From: Brian Banister
Sent: 22 April 2008 15:31
To: Planning.Responses
Subject: RE: Planning Consultation on: BR/110/08/

APPLICATION NO:	BR/110/08/
Registered:	15-APR-08
Site Address:	18 Lennox Street Bognor Regis
Grid Reference:	493505 - 98919
Category:	Plan Applicat'n
Description of Works:	Outline application for the redevelopment of premises to provide 14 no. apartments

Norfolk Street Elevation

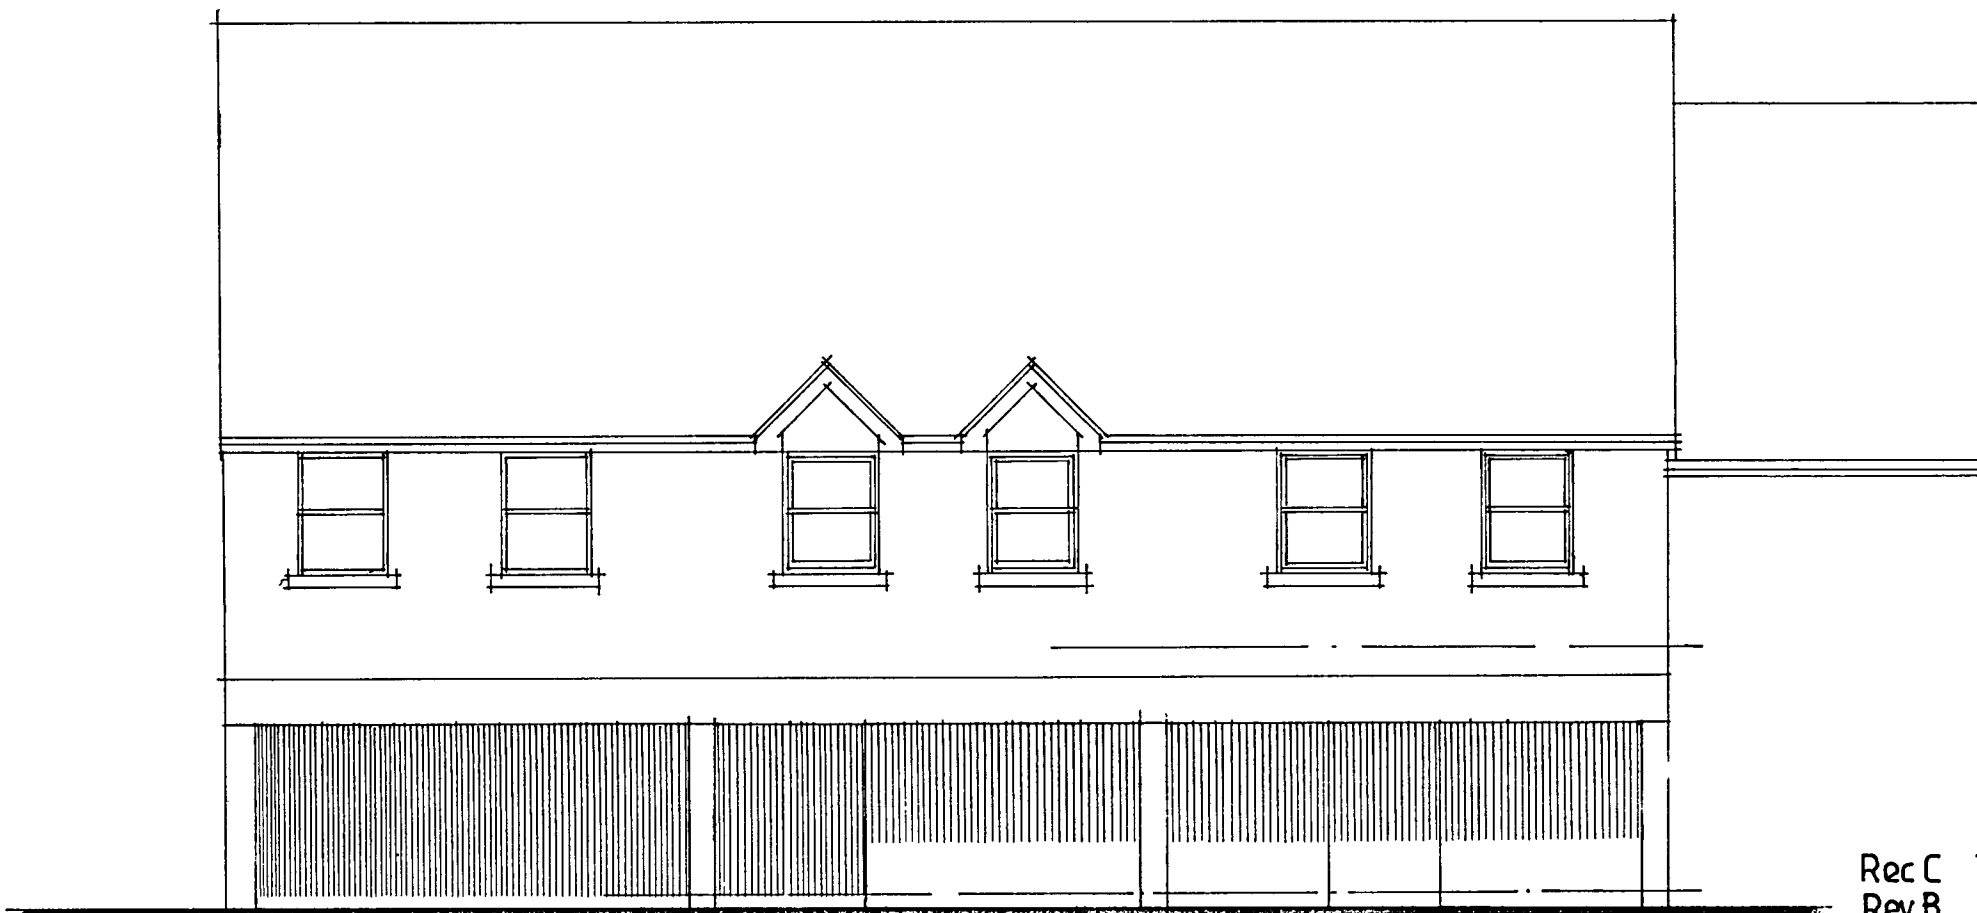
Just outside the Conservation Area although the opposite side of Norfolk Street is within. We have always stressed the importance of not having blank facades on to Norfolk Street and I am a bit concerned that there is an open covered parking area proposed. However, there may be the possibility of introducing individual sideways sliding timber garage doors and these would roll up internally within the individual garages. It may be that the garages need to be wider than shown in order to achieve this (reduce from 6 to 5?). incorporating these would provide a more interesting ground floor facade and to some extent be in keeping with the locality. I consider the scale of the development to be generally satisfactory although a street scene drawing would have been useful.
